# KITTITAS COUNTY DEPARTMENT OF PUBLIC WORKS

January 26, 2021

Below is a list of questions and comments relating to the grading permit associated with the Hansen Road Development.

DRAWING NO.	C1.5
PROJECT NO.	20.010
DATE:	11/23/20
SHEET NO.	6 OF 10

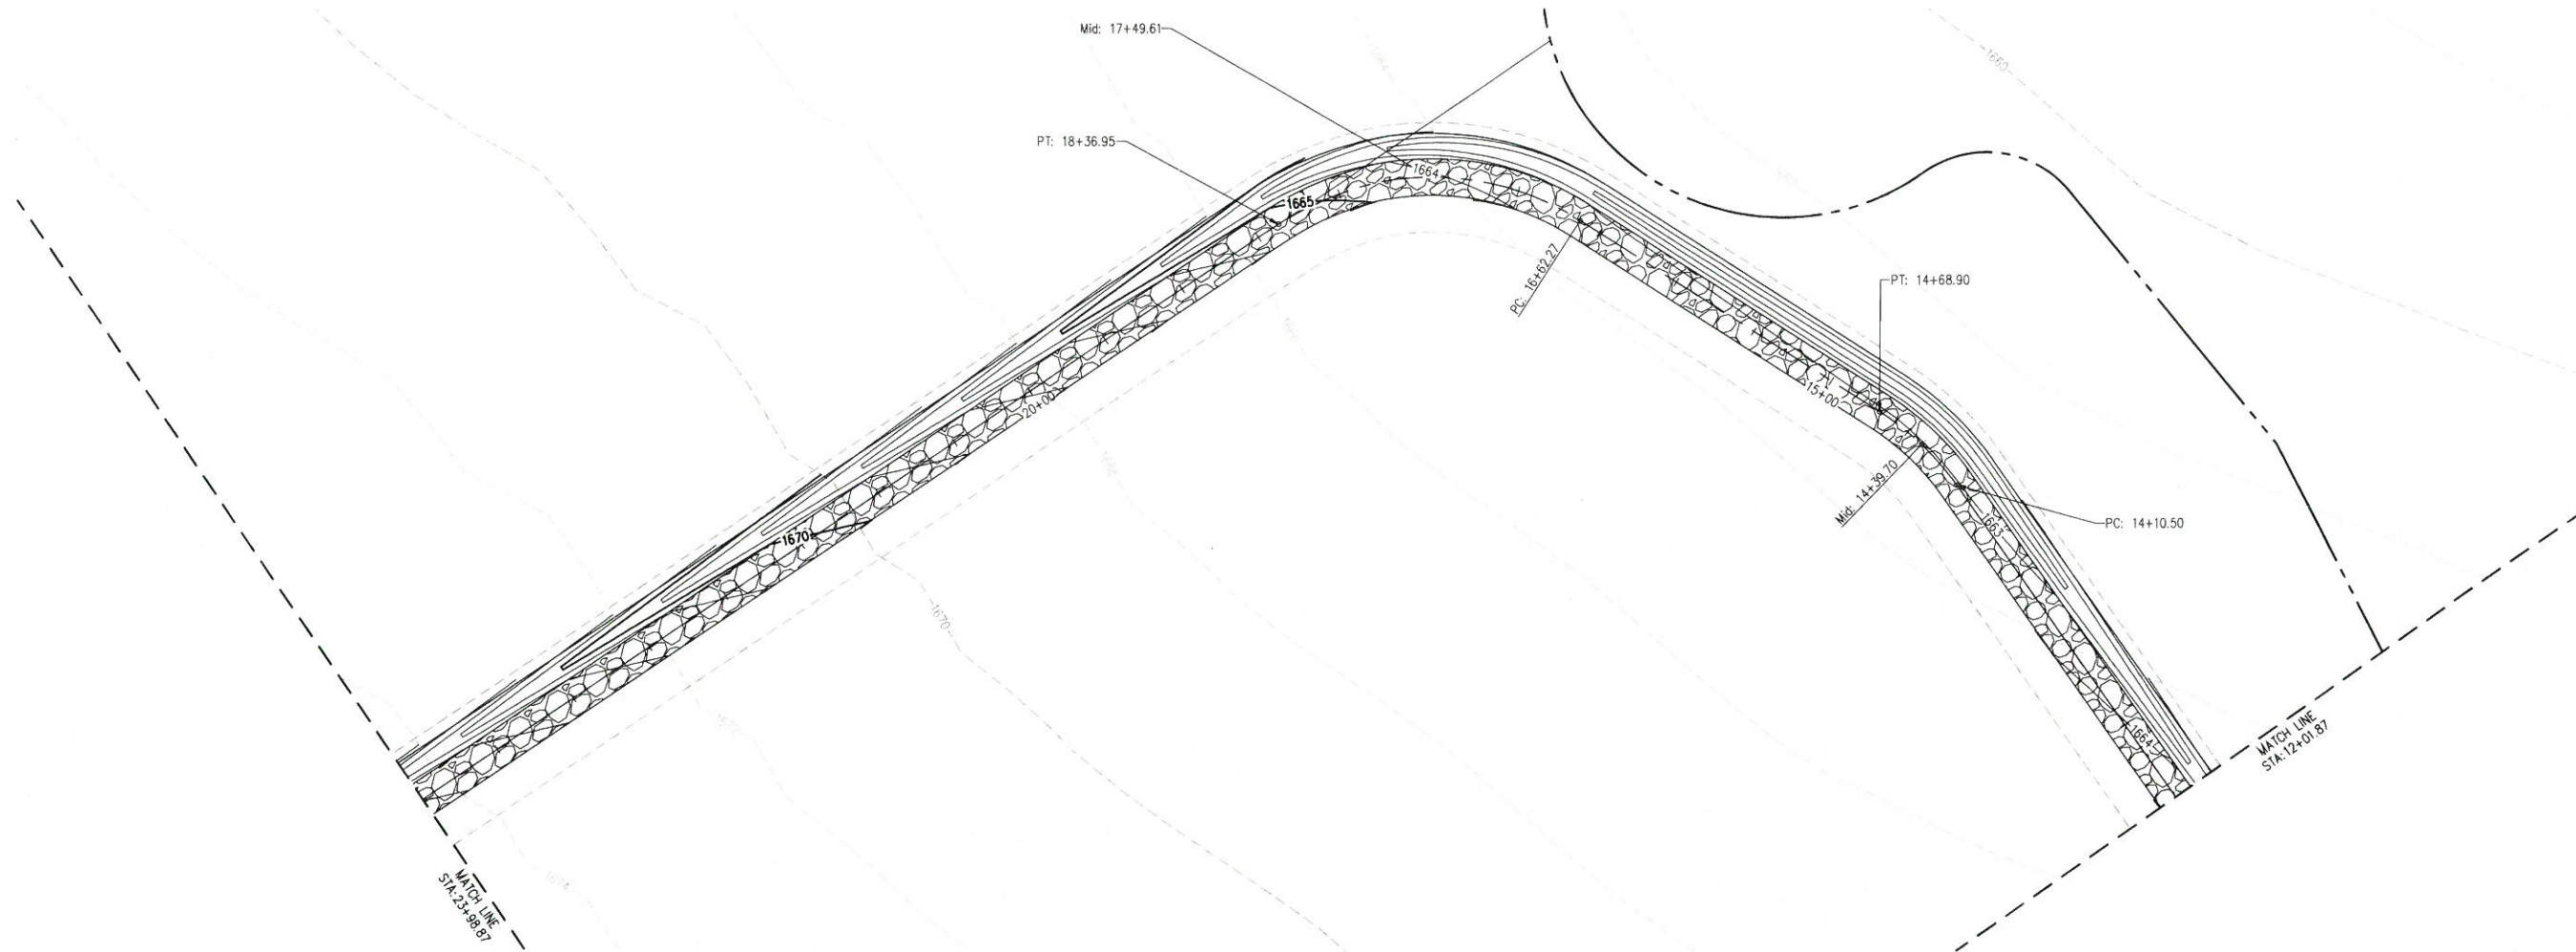
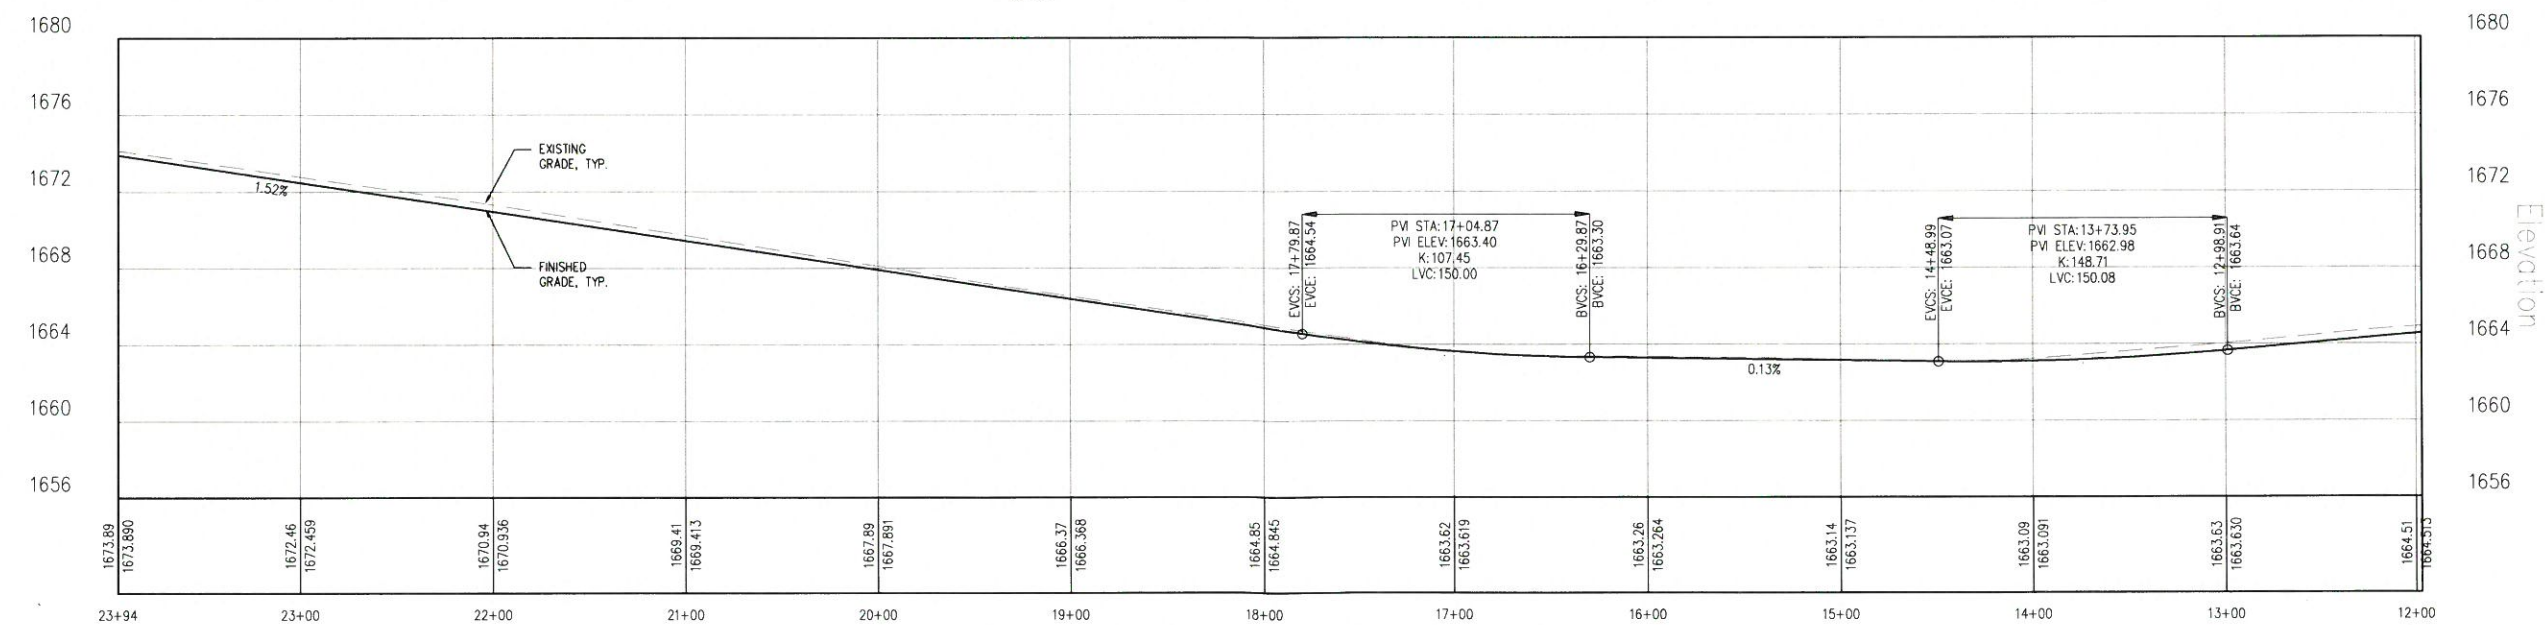
19. C1.4 through C1.8 please identify lot lines and lots.
  20. Identify the existing access to parcel 836636 and identify the spacing from edge of access to the edge of the proposed access. Ensure spacing meets requirements of KCC 12.5, particularly Table 5-1.

DRAWING NO.	C1.7
PROJECT NO.	20.010
DATE:	11/23/20
SHEET NO.	8 OF 10

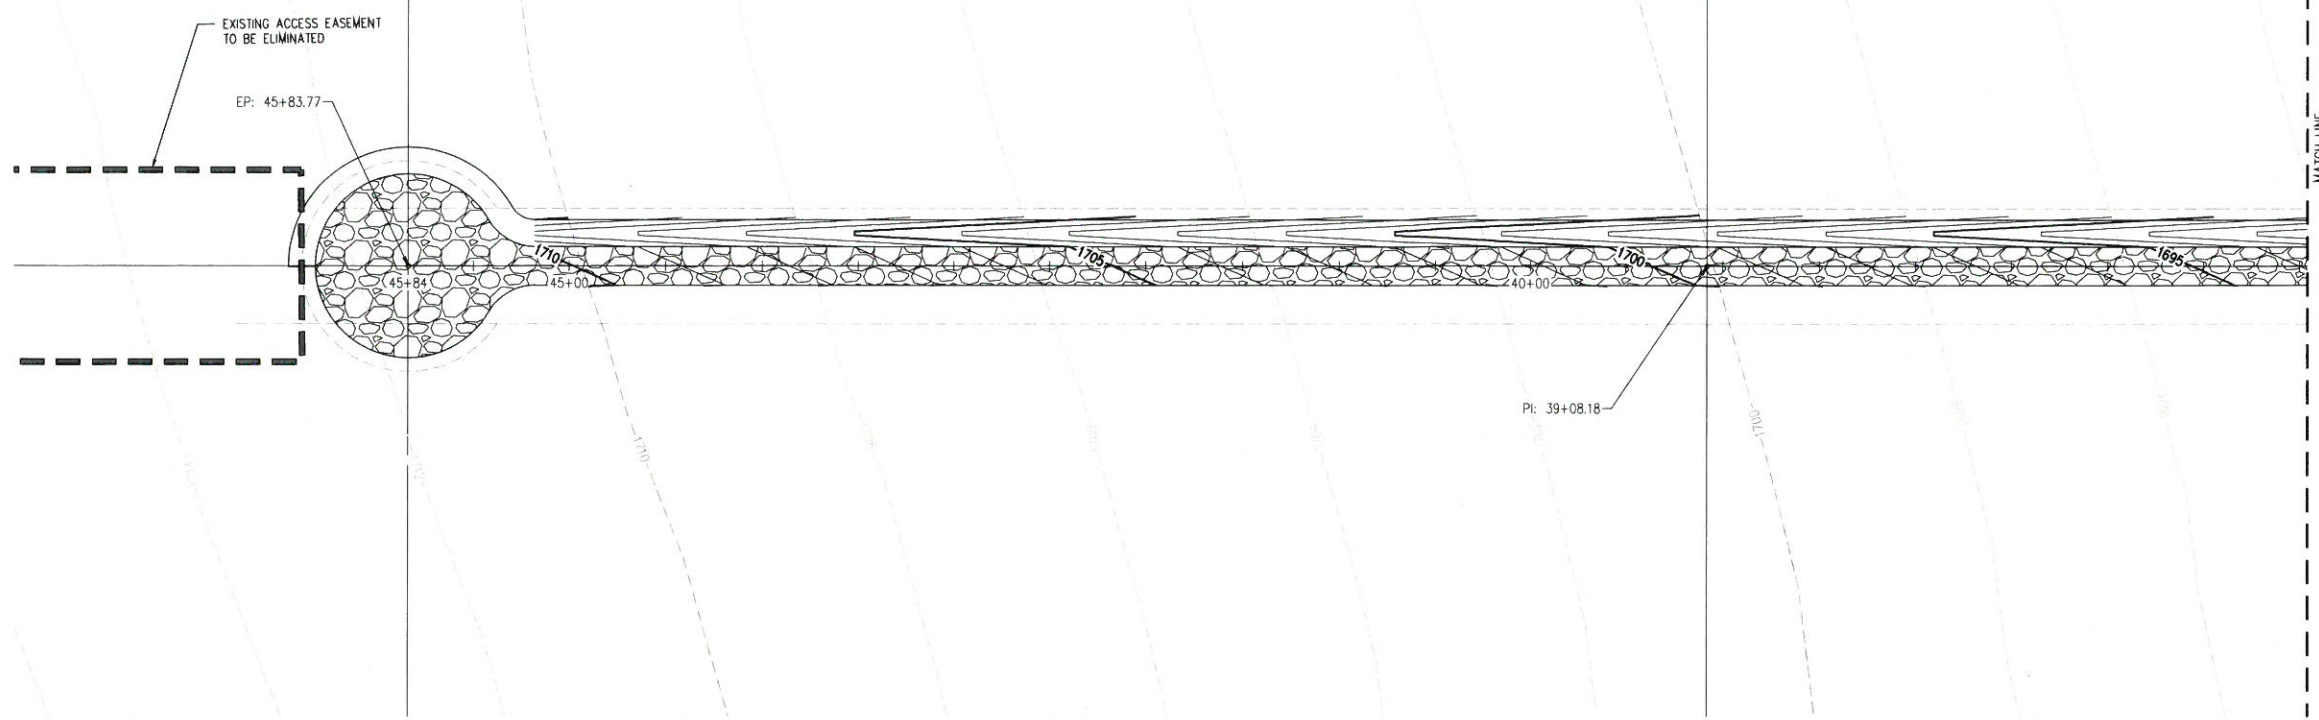
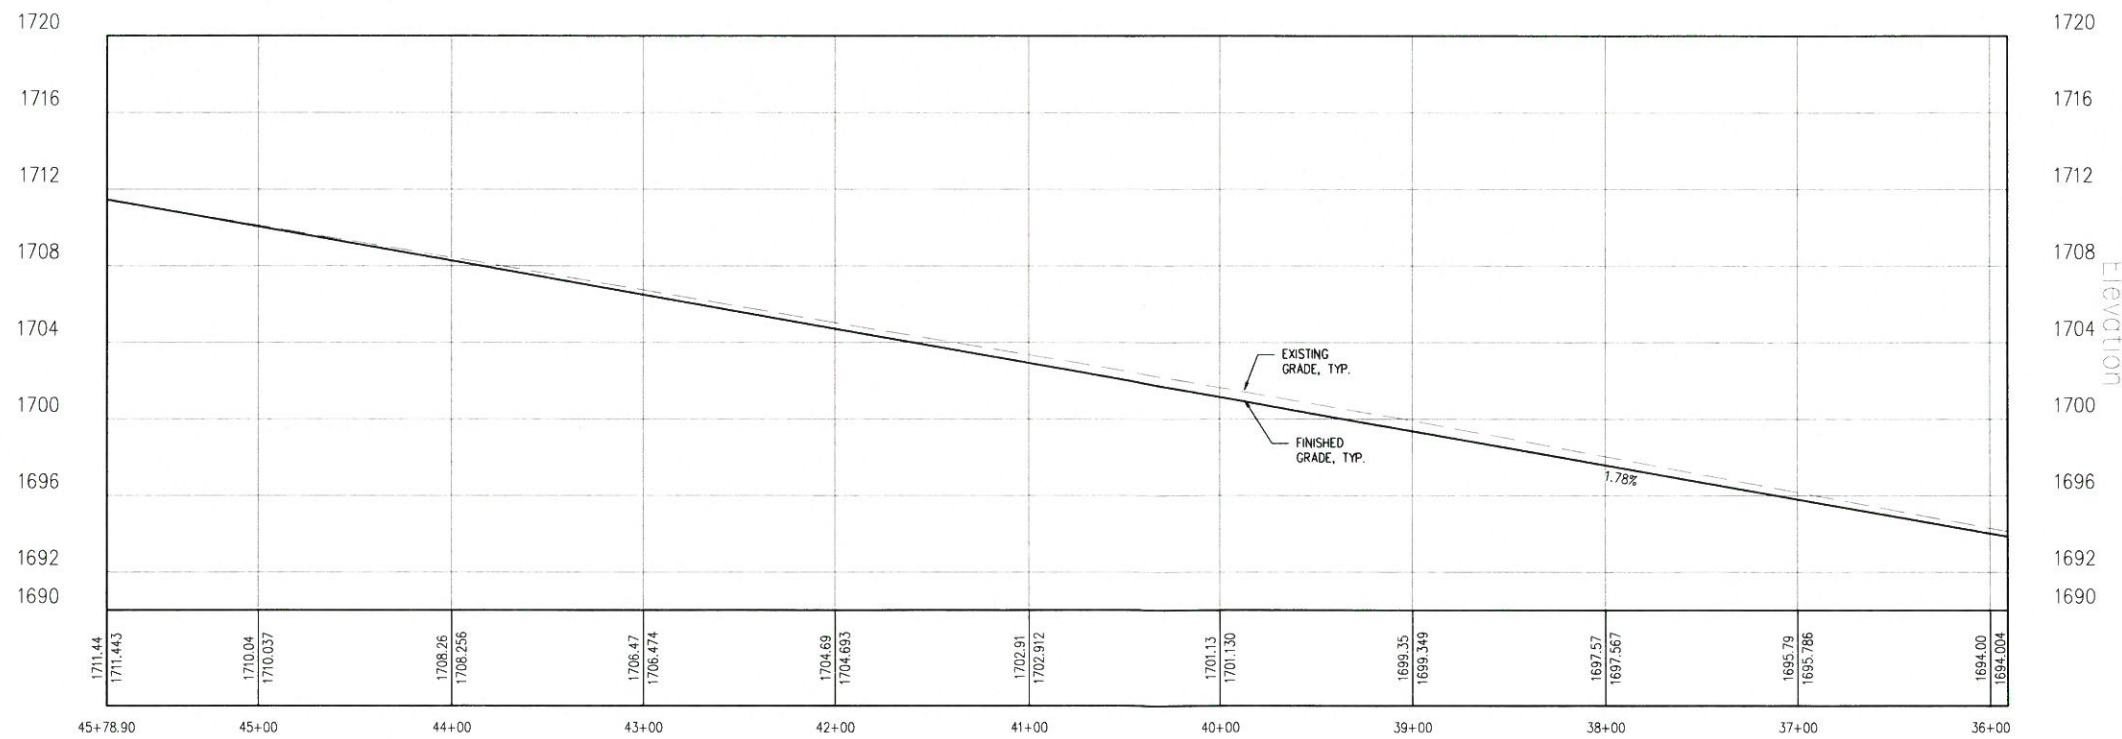
5. Notes on sheets C1.1 and C1.7 mention that there is an existing access easement off Hansen Road to be eliminated. Does this mean that there is an existing road that needs to be removed? If so, please provide additional details on the removal of the road and adjust the TESC plan to include the road removal within its limits.

DRAWING NO. **C1.9**
PROJECT NO. **20.010**
DATE: **11/23/20**
SHEET NO. **10 OF 10**

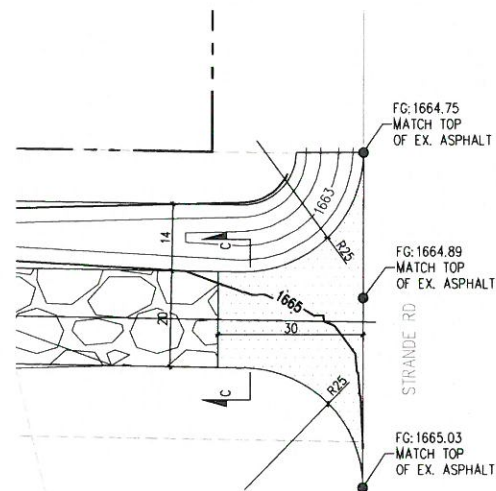
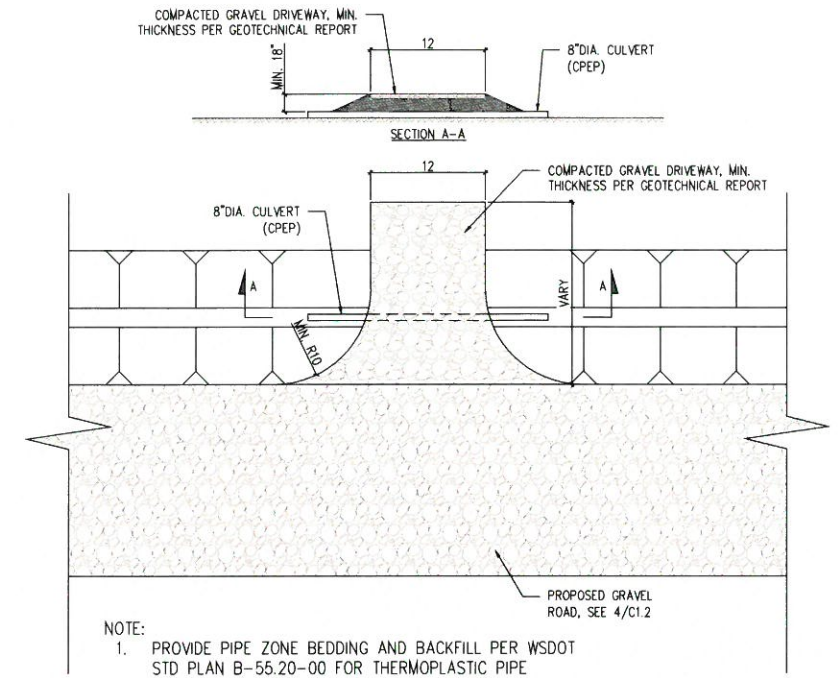
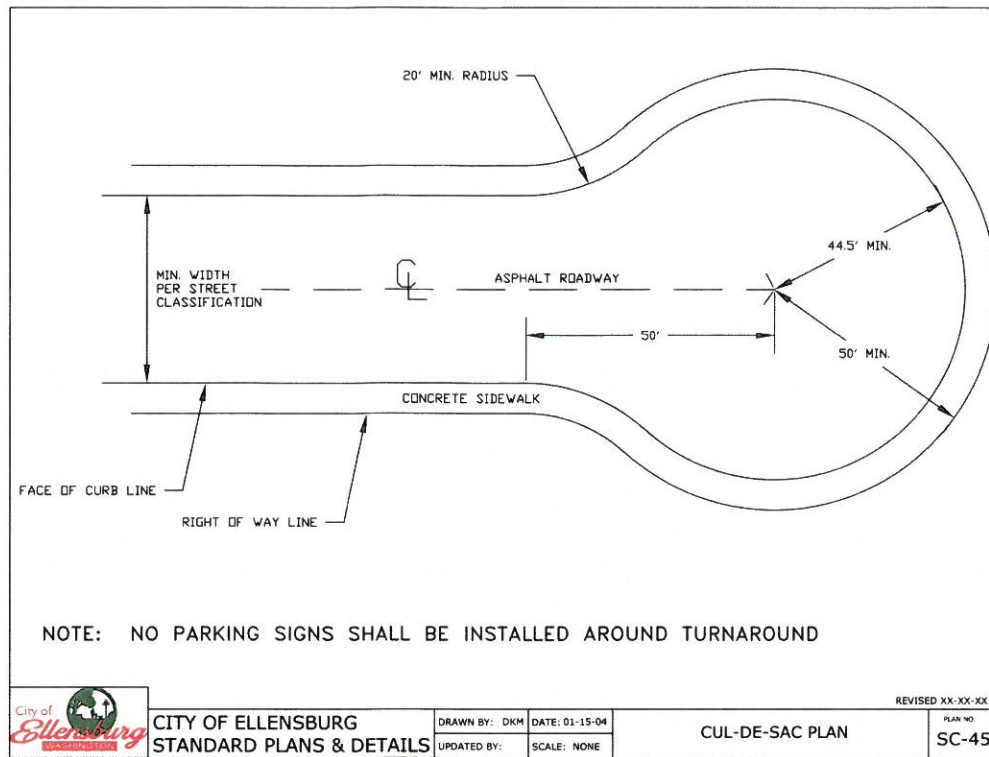
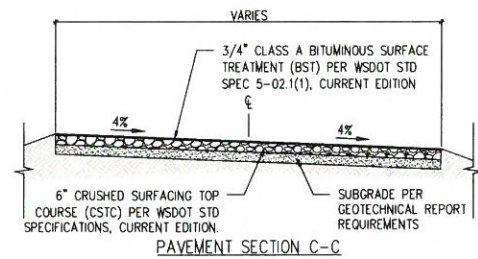
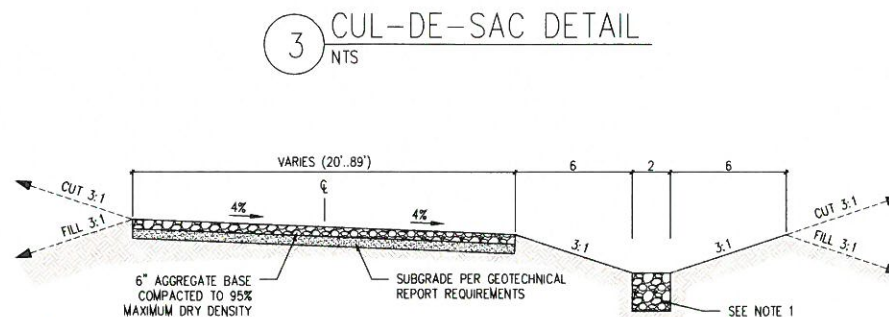
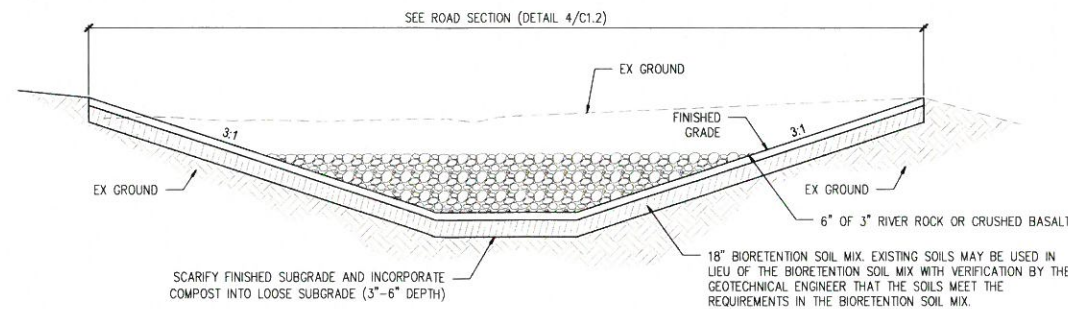
3. Original administrative segregation included 12 lots. Parcel 748433 should be shown as having access to proposed private roadway.
4. Throughout the plan set, notes refer the reader to details on page C1.2. For example, sheet C1.1 has notes for the cul-de-sac, paved apron, gravel road, and drainage basin referring the reader to 'see 2/C1.2', 'see 3/C1.2', etc. Similar notes appear on sheet C1.9. Should these notes refer the reader to C1.9?

12. C1.9: The Cul-De-Sac detail needs to show a minimum diameter of 96' to meet international fire code.
13. C1.9: The Cul-De-Sac detail shows a concrete sidewalk. A sidewalk isn't shown throughout the rest of the plan set. Please amend this detail match the rest of the plans.

14. C1.9: Detail 4 shows the road width as 'varies' from 20' to 89'. Kittitas County Code (KCC) 12.04.080 details design criteria for private roads, and based on the number of

- lots, this project should contain a 20' road width and 1' shoulders. Please adjust the road width to match these requirements.
15. C1.9 Detail 4: references 6" Aggregate Base, please reference WSDOT standard for material.

16. C1.9 Detail 2: provide additional detail related to the roadside drainage along Strande Road and how the proposed access will impact. Review the need of culvert, and grade catch points. Plans indicate topography is based on contours, this may be insufficient to provide connection and drainage details for the connection to Strande Road.

17. C1.9: Detail 2, 4 and 6 reference a geotechnical report. Please provide a copy.
  18. Provide details of proposed gravel road shown on sheet C1.8. Also, provide easement width. Please clarify lot line locations.
